**WELWYN HATFIELD BOROUGH COUNCIL
EXECUTIVE DIRECTOR - PLANNING, PUBLIC PROTECTION AND GOVERNANCE**

Application No: 6/2022/2450/EM
Location: 16 Walden Road Welwyn Garden City AL8 7PF
Proposal: Part single storey and part two storey rear extension, single storey side extension, Velux loft conversion, alterations to openings, patio area with balustrading and addition of solar panels to existing and proposed roofs.
Officer: Mr James Homer

Recommendation: Refused

Drawing No: 5592-P01 Revision: B

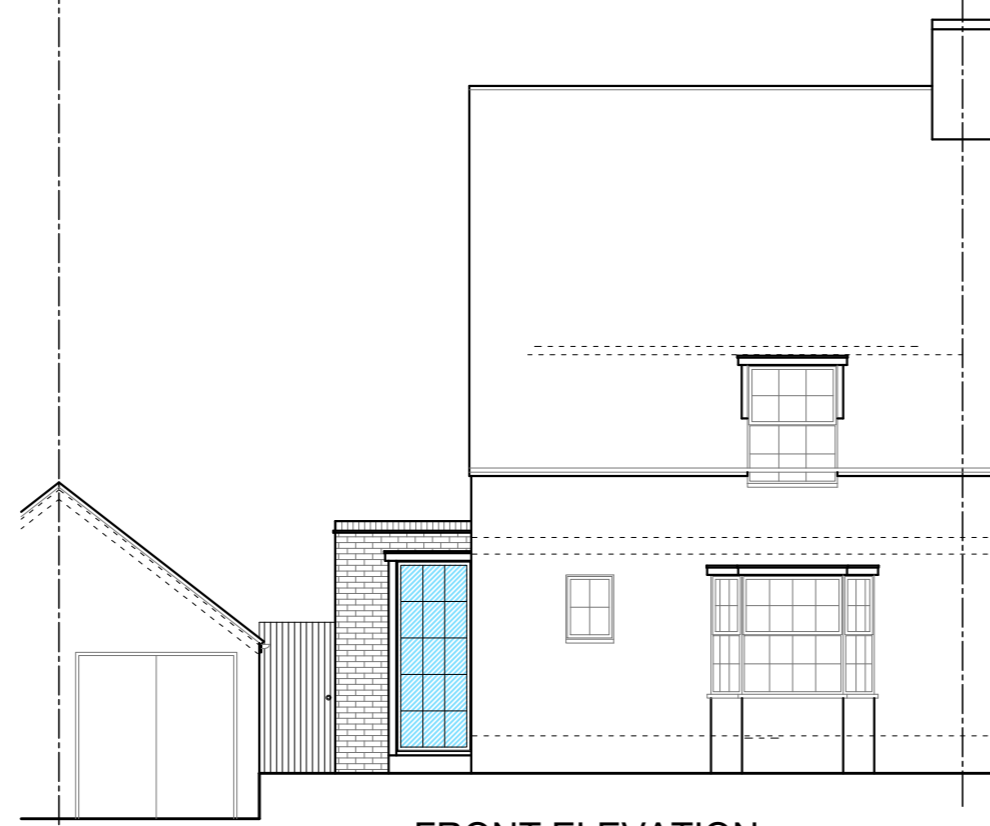
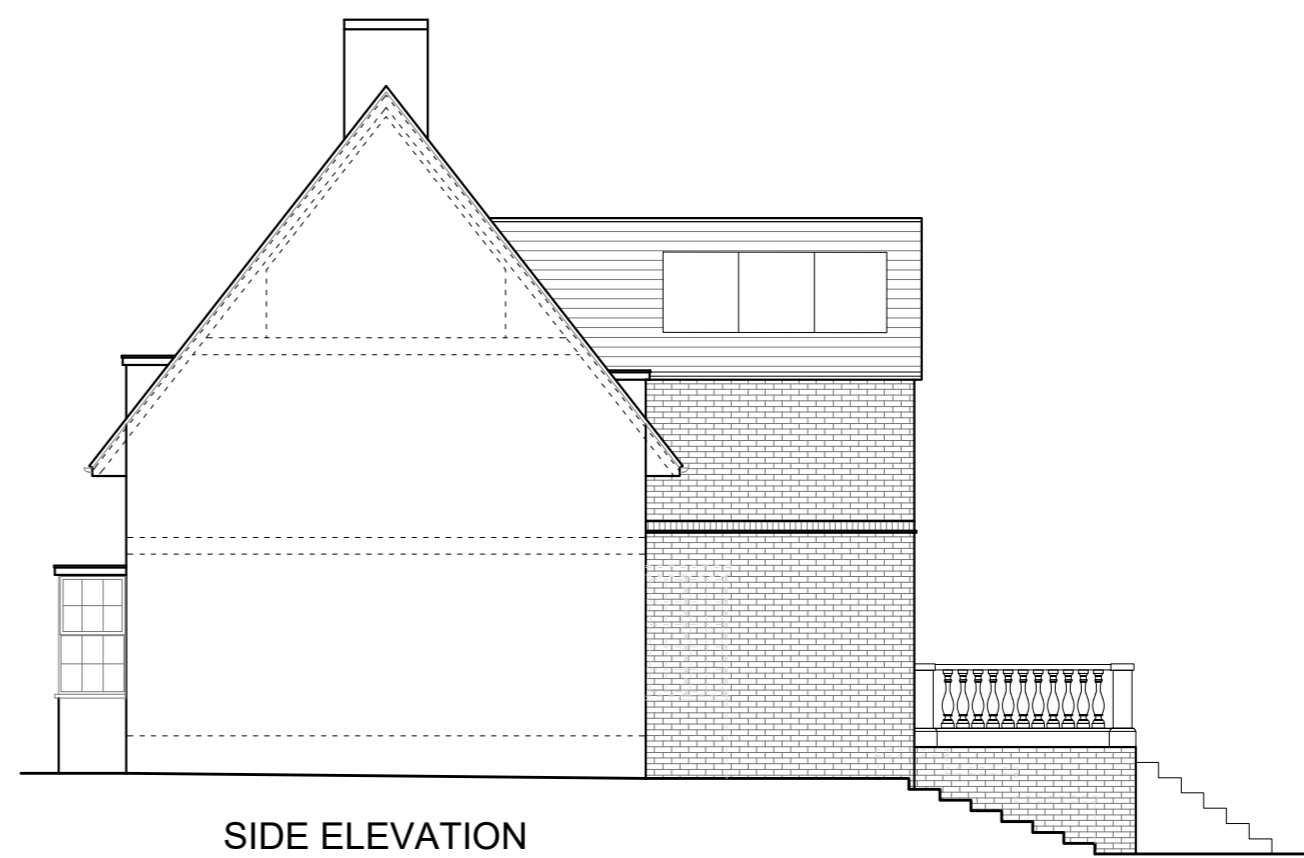
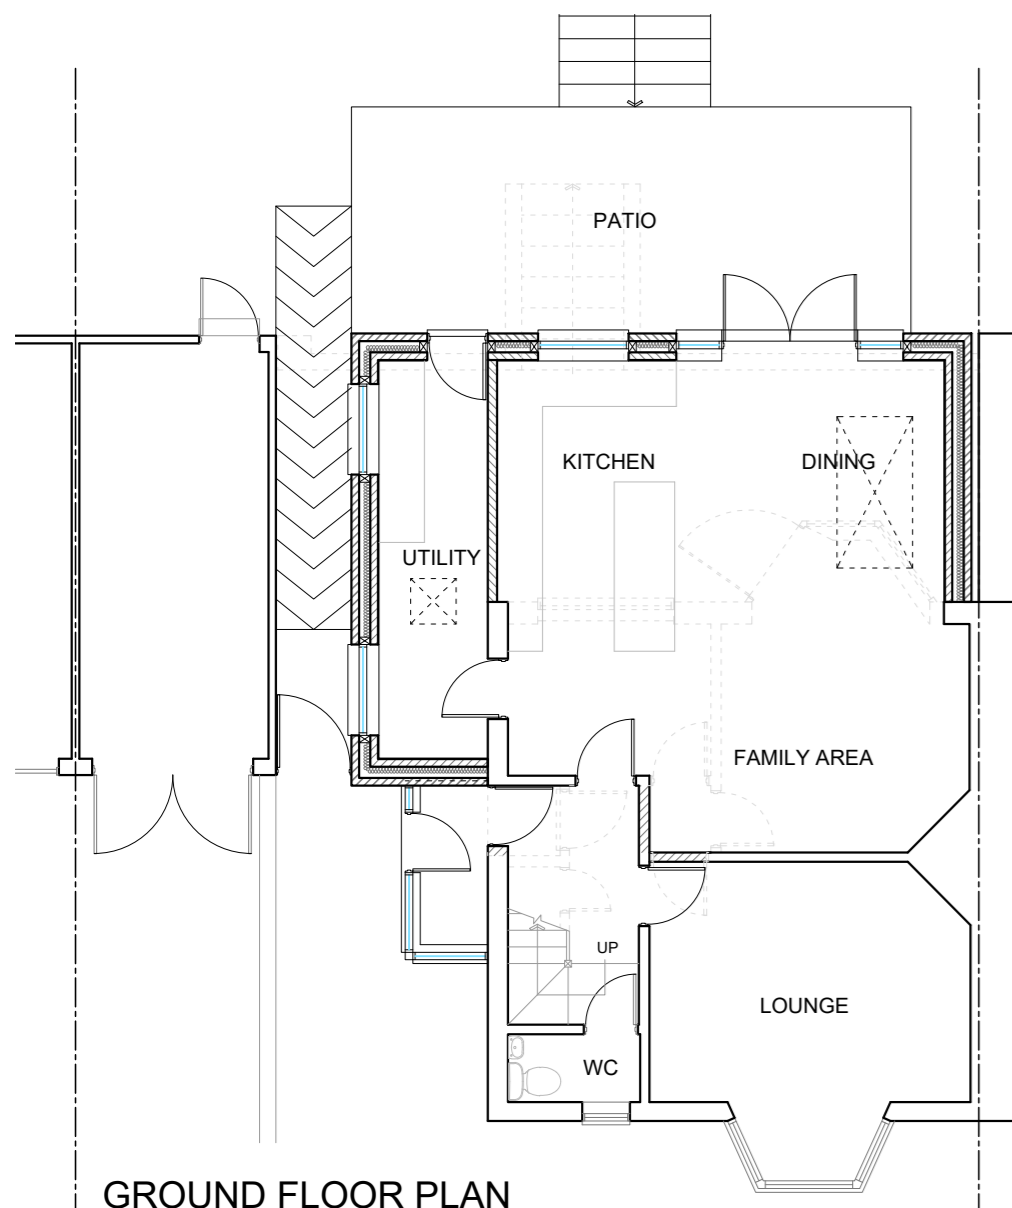
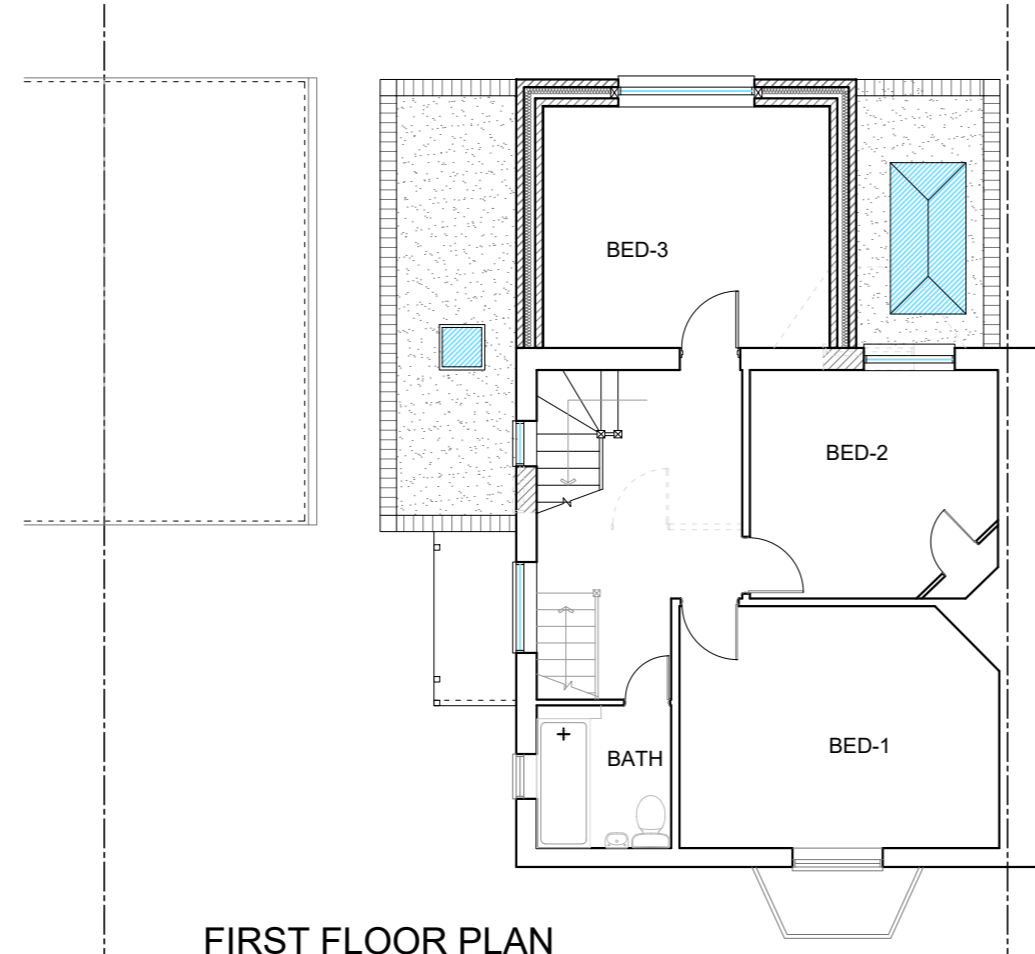
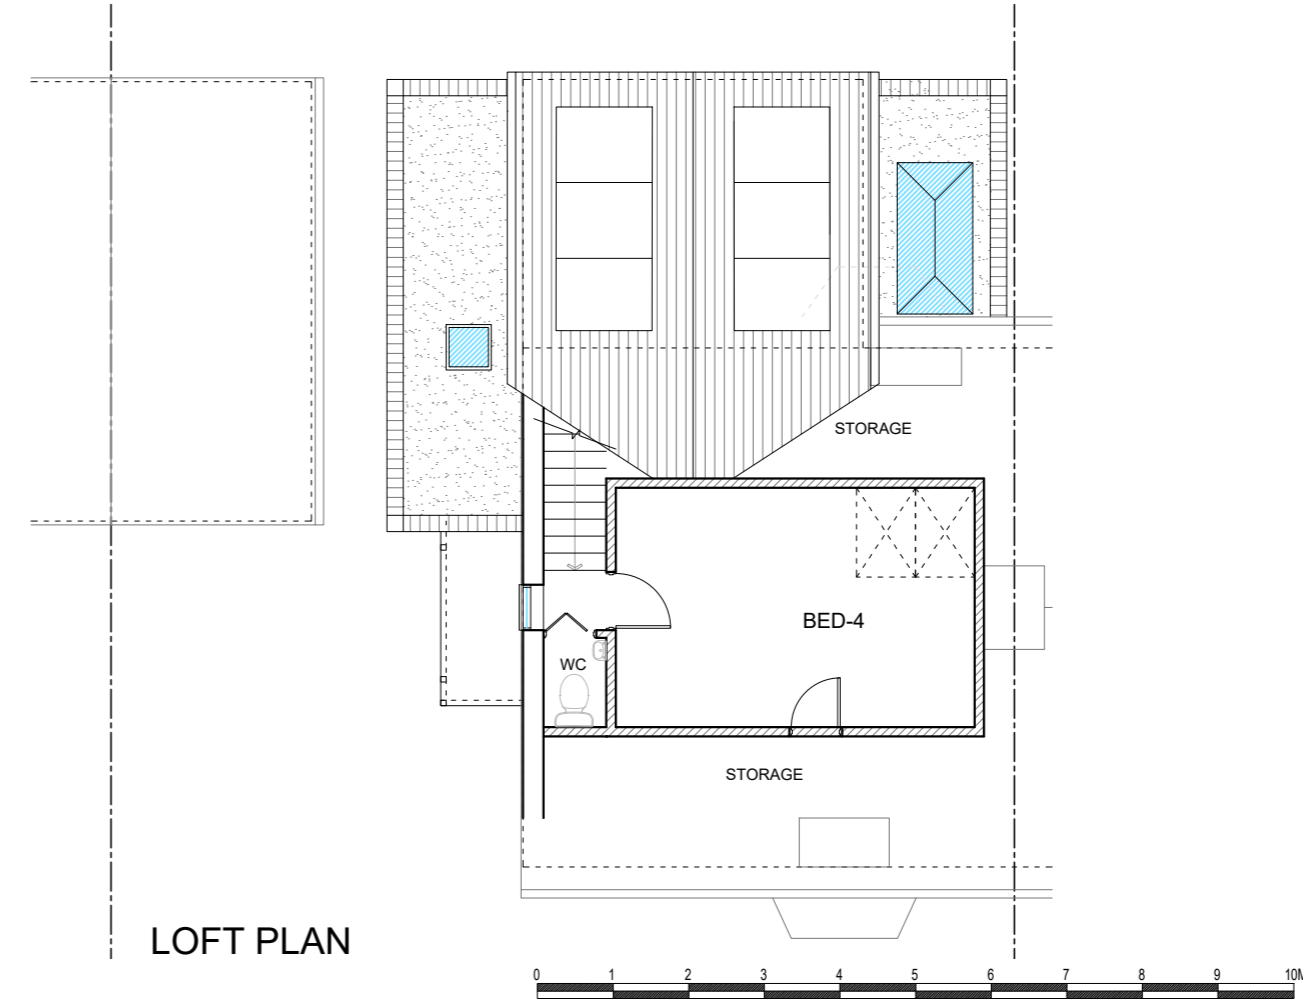
<p>cramped and overly dominant addition. This dominant appearance is exacerbated due to the raised patio area, change in topography across the application site (drop in levels at the rear of the house), its elevated position in relation to no.18 and the wide visibility of the side of the property from the street.</p> <p>The application also proposes to convert the loft into habitable space by inserting a porthole window within the gable end of the main house and inserting a roof light in the rear facing roof slope. These additions are not considered to result in harm to the appearance of the property or character of the wider street scene.</p> <p>Alterations to window openings within the flank gable of the existing home are proposed to enable internal modifications. The proposed alterations are considered in keeping with the appearance of the property and would not harm the character of the area.</p> <p>Finally, the application proposes to install a solar array upon the rear roof slope of the existing home and an array on each side of the roof of proposed first floor extension. Within the Estate Management Scheme area, solar panels should be arranged in a rectangular form, to avoid fragmentation and varying edges, and should be set suitably down from ridges and in from sides. In addition, when visible, panels should be concentrated to one roof plane only with multiple installations avoided.</p> <p>Despite the multiple installation proposal, this element of the scheme may be acceptable as they are generally rear facing. However, it is recommended that the solar array for the rear facing roof slope is set down and in so that it is sited more comfortably within the roof slope.</p>

1. Although elements of the proposal may be considered acceptable, the proposed rear extension and proposed side extension would not appear subordinate or proportionate in scale or appearance to the original home and associated garage resulting in cramped and overly dominant additions. This dominant appearance is exacerbated due to the raised patio area, change in topography across the application site (drop in levels at the rear of the house), its elevated position in relation to no.18 and the wide visibility of the side of the property from the street. Accordingly, the application fails to comply with Policy EM1 of the Estate Management Scheme.
